Application number: 2021/90090	
What is the application for?:	Variation condition 2 (plans) on previous permission 2017/91596 for change of use
Address of the site or building:	Egypt Farm, Cliffe Lane, Gomersal, BD19 4EU
Postcode:	BD19 3HW

Type of comment: An objection	
Do you wish your comments to be published on the website anonymously?	No
Eleven roof windows/sky light windows have been placed in the roof of the barn. They are not low profile and are not in keeping with the age and character of the barn. Have a detrimental effect to the barns appearance. Windows in the roof have been refused in previous planning applications. They can be seen from miles around. * Extra Floor in the barn Refused on previous planning applications, takes away the open character, original beams removed in the process. Extra bedrooms created. No visitor parking for either barn, access to number 58 Cliffe Lane is blocked almost daily due to this. Would emergency vehicles be able to enter number 58 easily if needed? * Window in the top floor east elevation of the barn Over looks numbers 60/62 and 64/66 Ye Closes which is listed, takes away all privacy to these houses, a bat box should have been placed

Western Elevation 1: 100

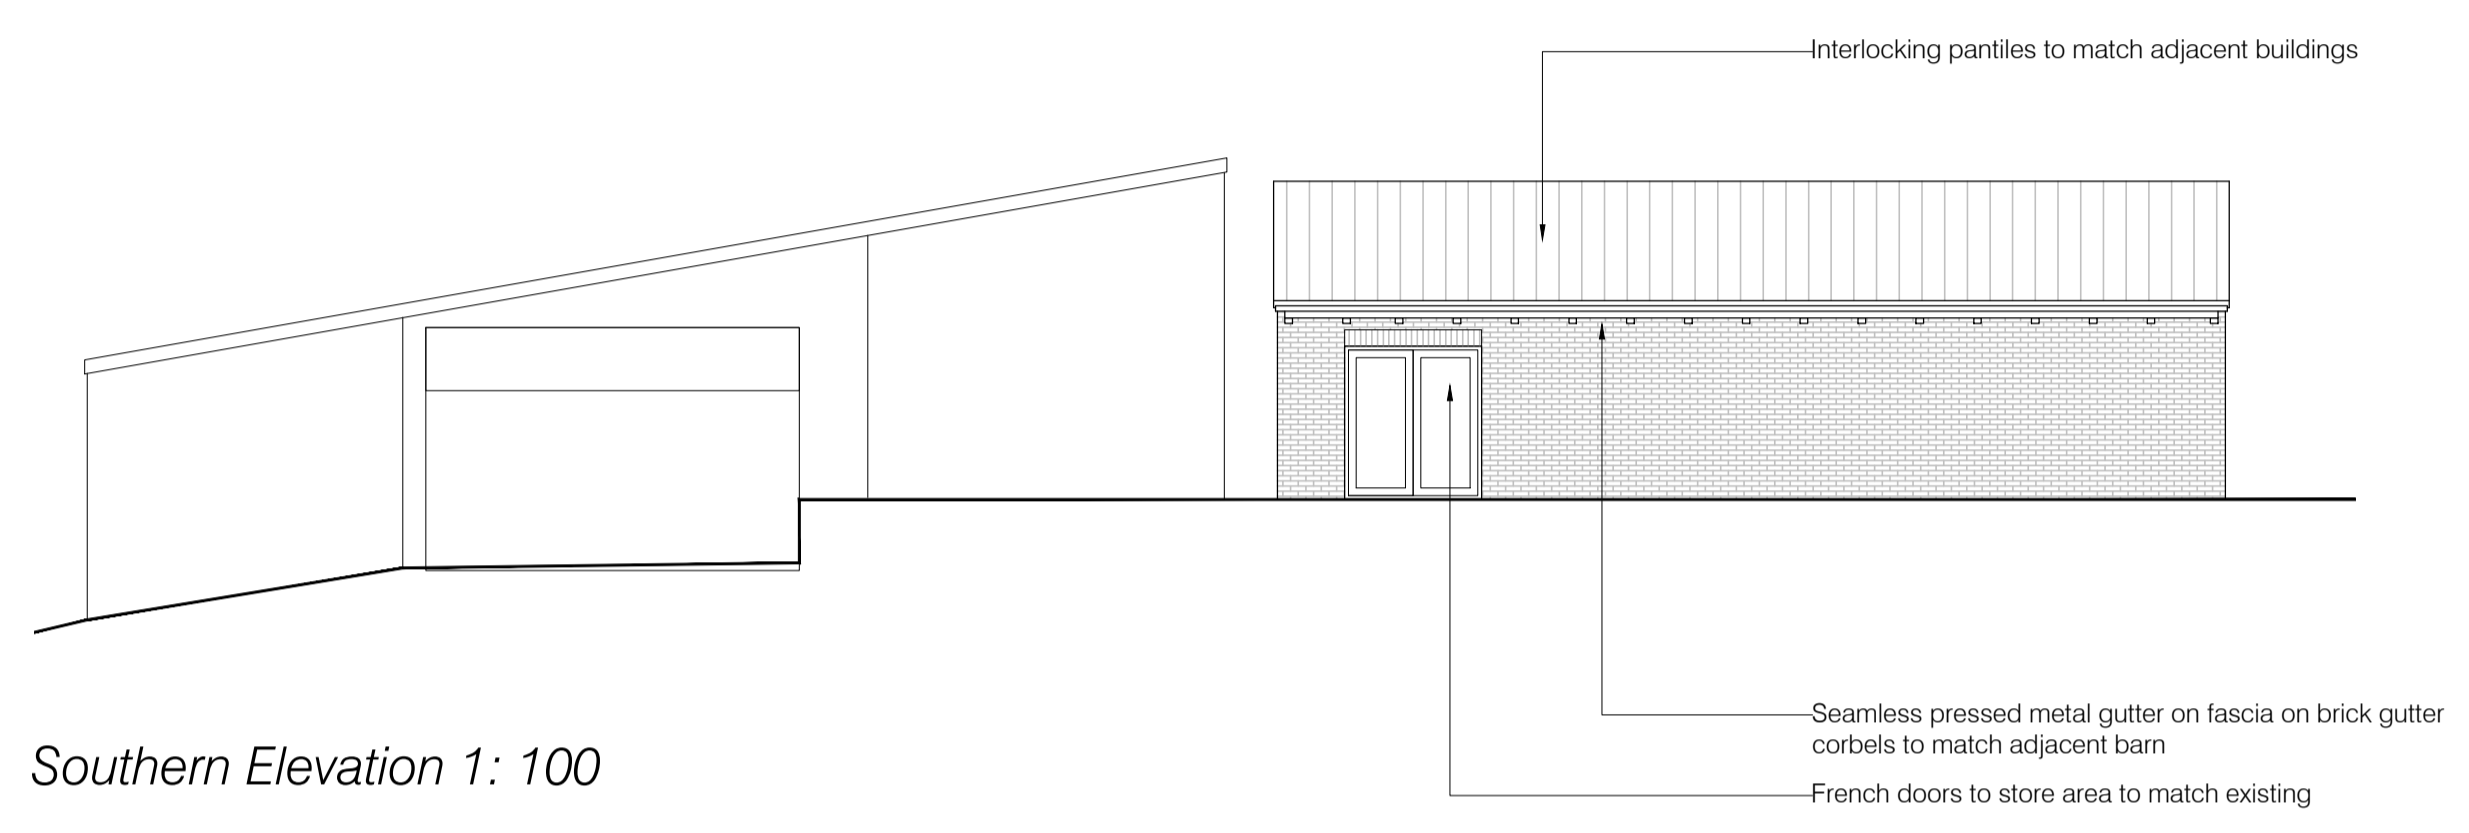
windows in the west elevation of the barn.

Already in place, planning permission not sort by the developer, not on new plans submitted, not passed on previous planning applications. Overlooks Egypt Farm, 58 Cliffe Lane

Eastern Elevation 1: 100

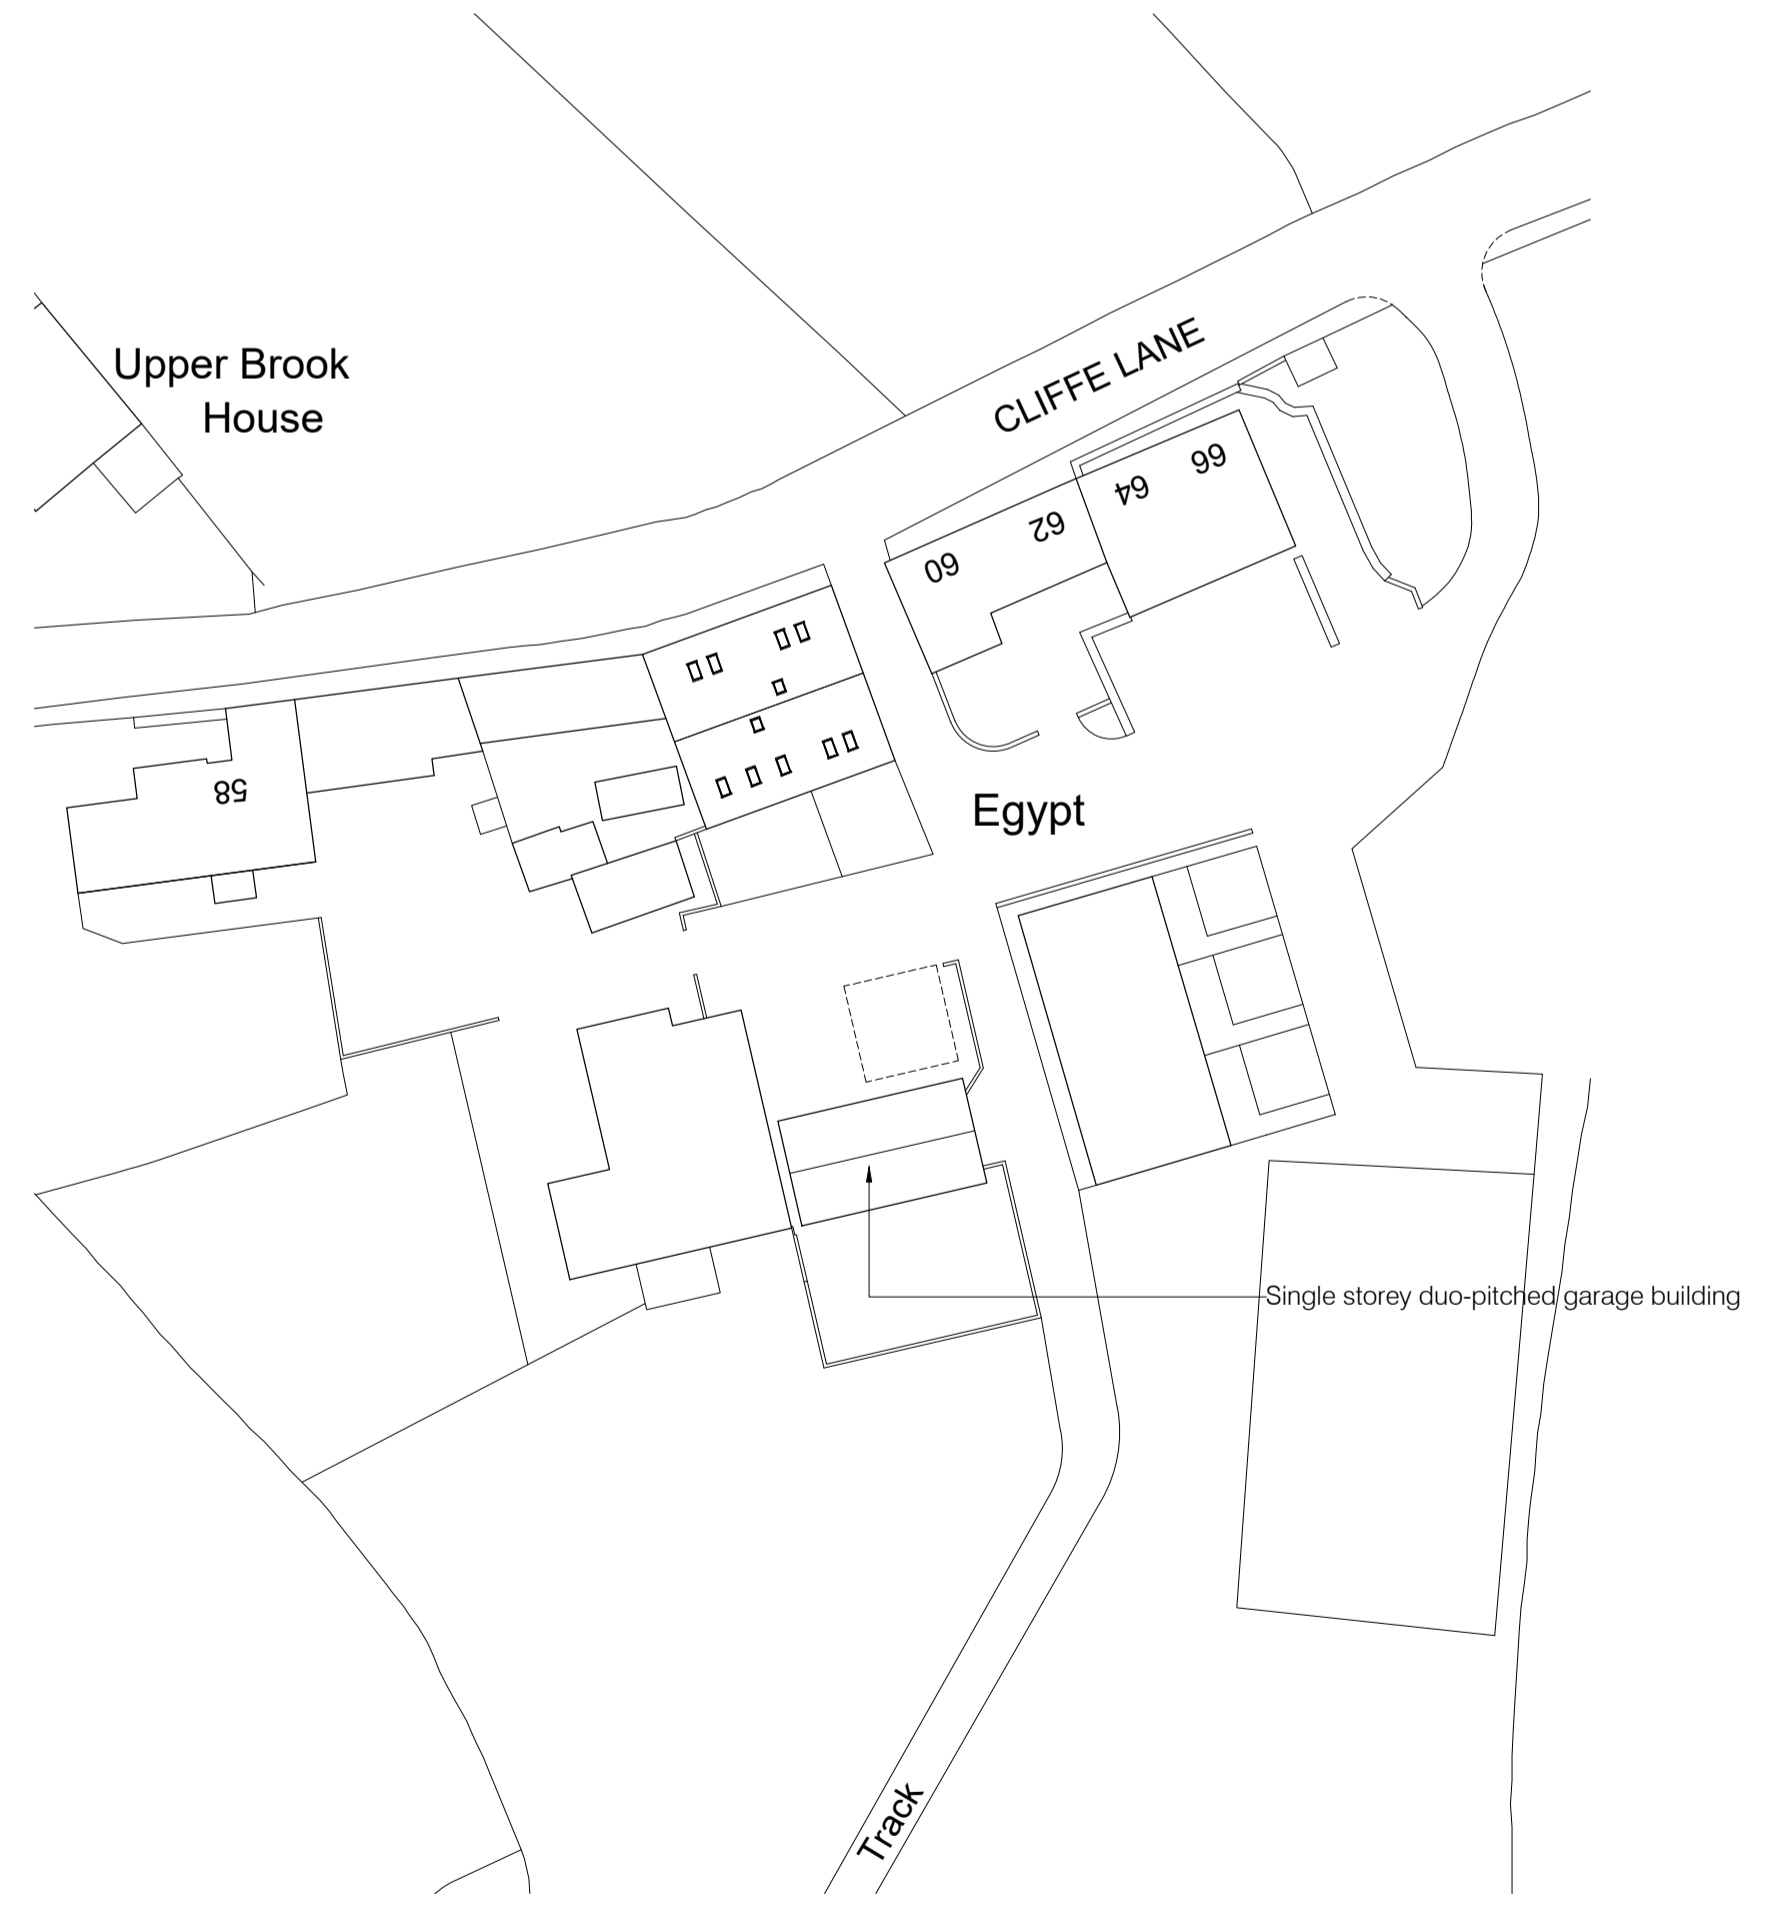
*Roller shutter in east elevation of garage/store space

Not in keeping with the farmstead, looks industrial. Opens onto a access track used daily by the owners of number 58 to move animals in to the fields. Public footpath runs down this track past the door. Noise pollution to houses 68/70/72. Garages/store room not passed by any previous planning applications. Garage door already in situ at the front of the garage, unsure why the developer needs two doors into the same garage/store room. Patio door at the rear of the garages/store room not needed for a building of this function.
